PCU057866

12 January 2015

**RE: Barangaroo Ferry Terminal (SSI 6727)**

**Figure 1-1 Barangaroo Ferry Hub key proposal features (Indicative only, subject to design development).**

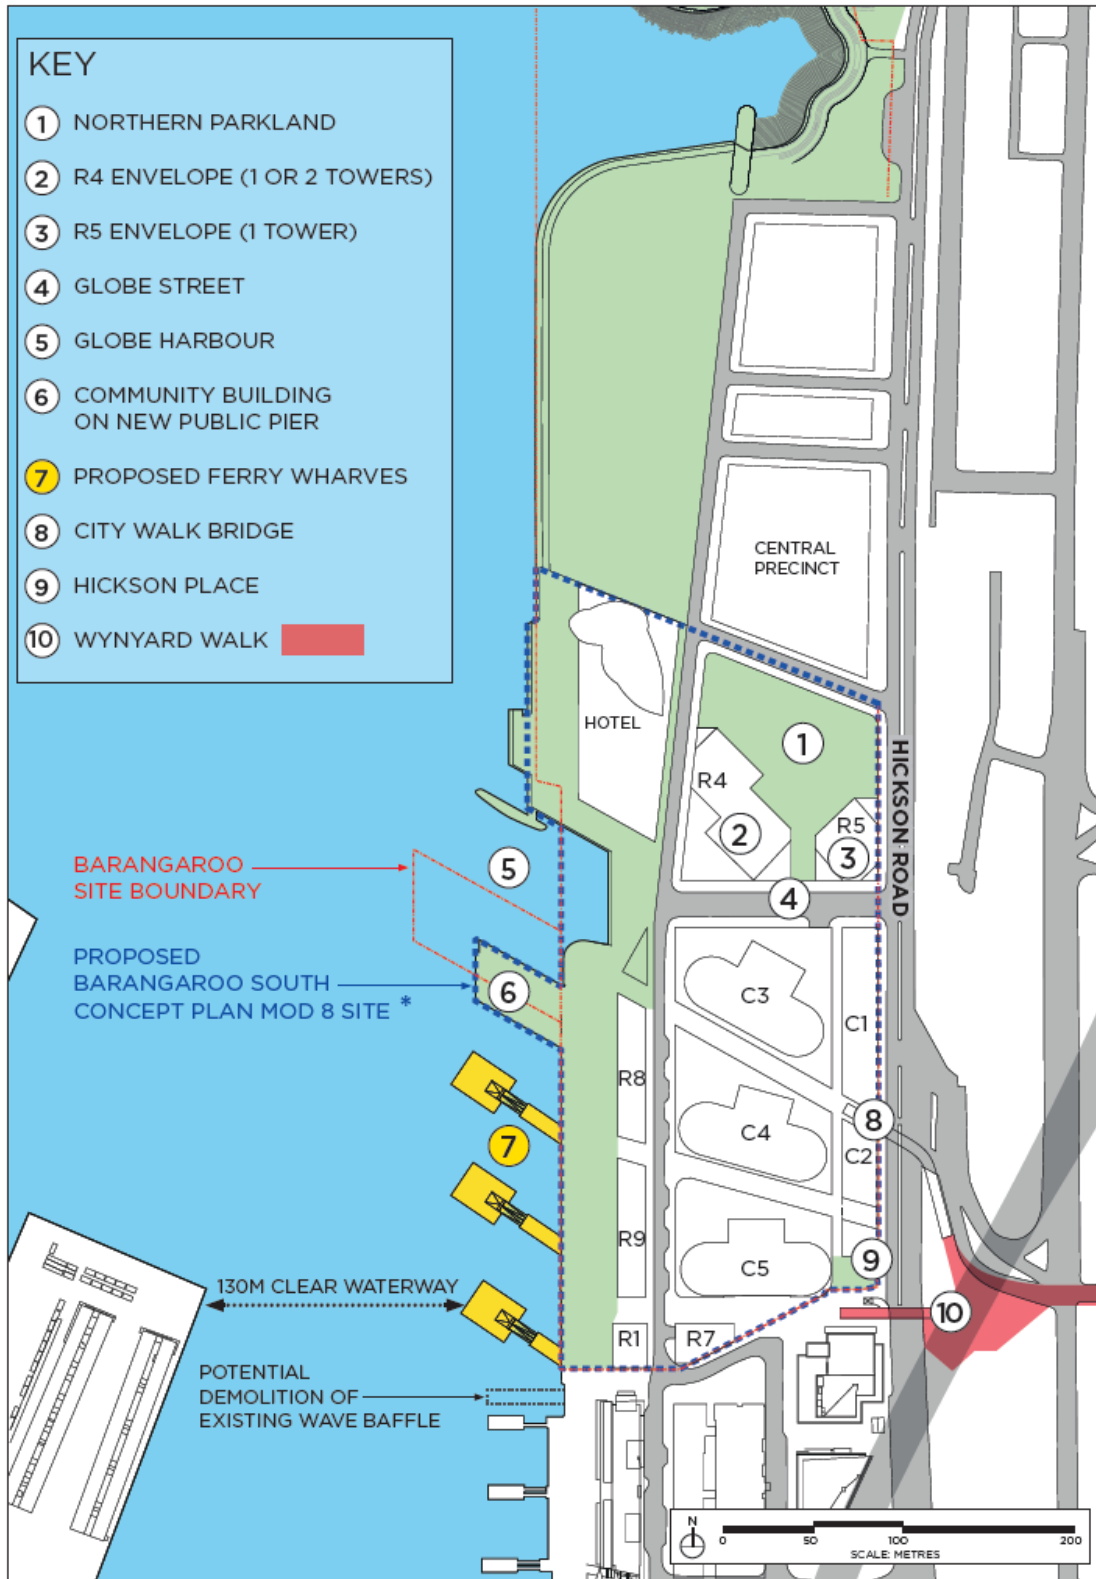
- The proposed "Wharf 1" may have an impact on Sydney Water's recently constructed stormwater channel outlet at this location. The proponent is required to provide further information regarding the proposed work in the vicinity of the stormwater channel outlet to assess the likely impact on Sydney Water's stormwater asset.
- No buildings or permanent structures are to be proposed over the Sydney Water's stormwater structures or within 1m form the outside face of the stormwater structures. This clearance requirement would apply for unlimited depth and height.
